Recommendation Report for Planning Permission for Works or Extension to a Dwelling

REF NO: BR/5/19/HH

LOCATION: 33 Elmwood Avenue
Bognor Regis
PO22 8DD

PROPOSAL: Two storey rear extension, single storey side extension & front porch extension.

FRONT ELEVATION SOUTH 1:100

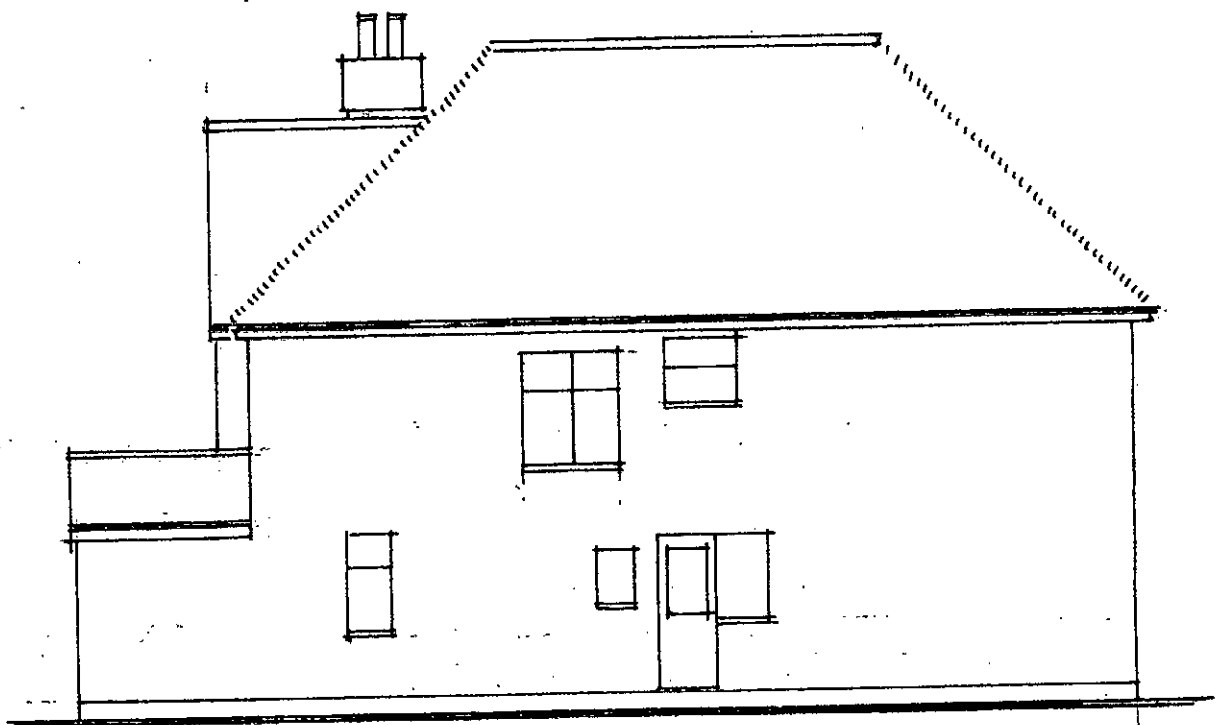
A porch will be constructed to the southern elevation and whilst this is in front of the principal elevation of the host dwelling and beyond that of the neighbouring properties, due to the varied design and styles of properties within in the area and with an example at No.34 of a front extension it is not considered the development will appear out of character with the area.

REAR ELEVATION NORTH 1:100

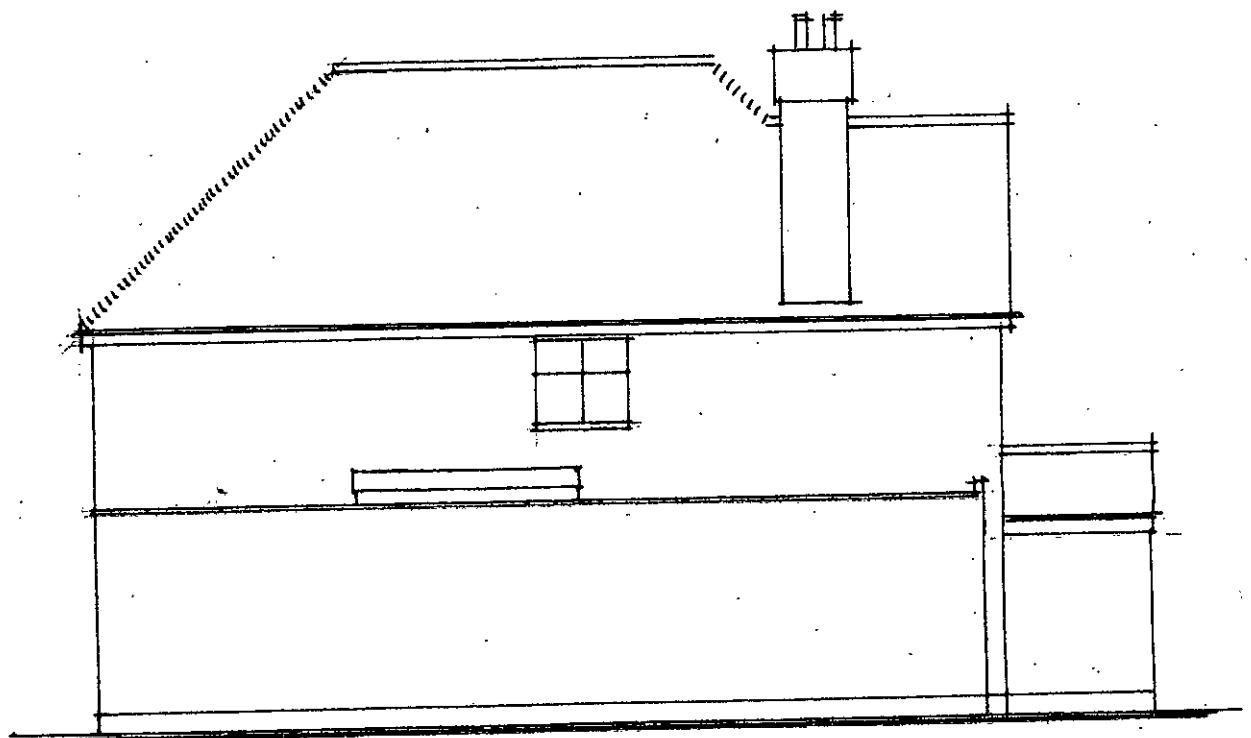
An existing conservatory to the rear will be removed and replaced with a two storey extension which will extend from the rear wall of the dwelling for a depth of approximately 3.5m. This extends slightly beyond that of the neighbouring dwellings. The height will match that of the existing dwelling with a hipped roof. The two storey extension extends beyond that of the property to the east and whilst it is close to the boundary it is not considered any impacts would be significant in which a refusal is justified. There will be 2 windows to the rear of two storey extension however they are not considered to give rise to any overlooking additional to that which can already be achieved.

The proposal will also install a first floor window to the western elevation however due to its siting and with no side windows to No.31 it is again not considered to give rise to any adverse overlooking impacts.

GROUND FLOOR
PLAN 1:100
EXTENSION

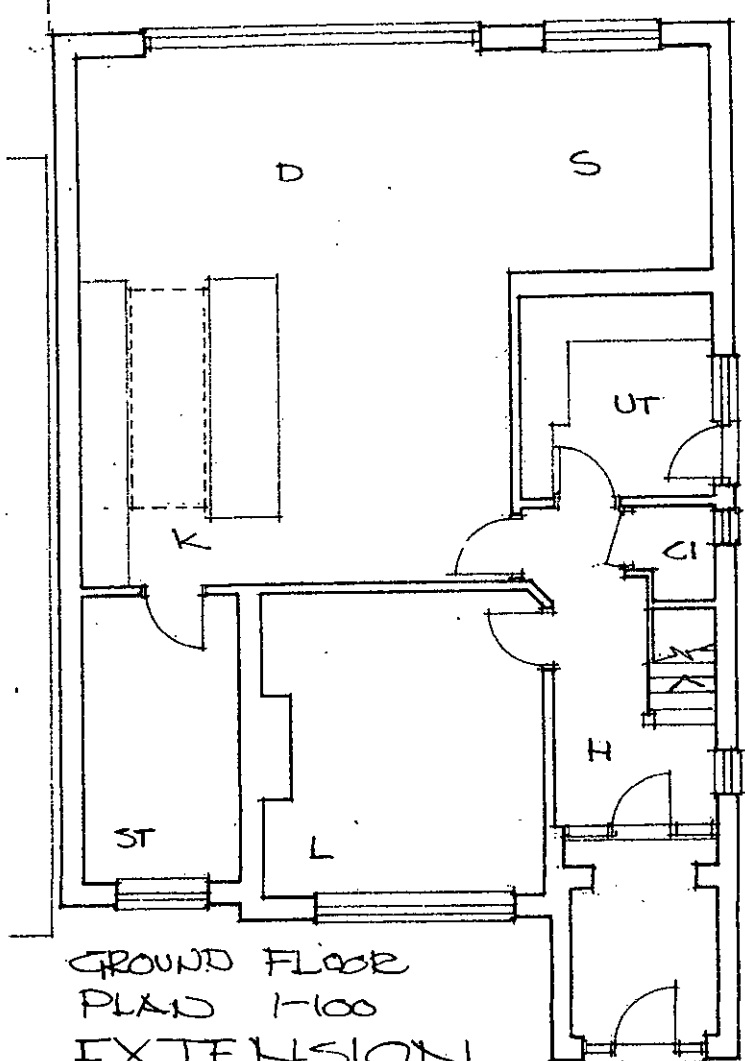
The proposal seeks to construct a single storey extension which will run along the full side elevation of the dwelling. This will have a depth of approx.11.5m which will meet with the proposed two storey extension at the rear. There is currently an existing covered area however the proposed extension will replace this. The side extension will be constructed to a height of 3m to a maximum of 3.4m with a roof lantern. This is slightly taller than existing however the neighbouring property at No.31 has a garage to this elevation and with no windows to its eastern side elevation the development is not considered to give rise to any adverse impacts upon the neighbouring amenity to this elevation.
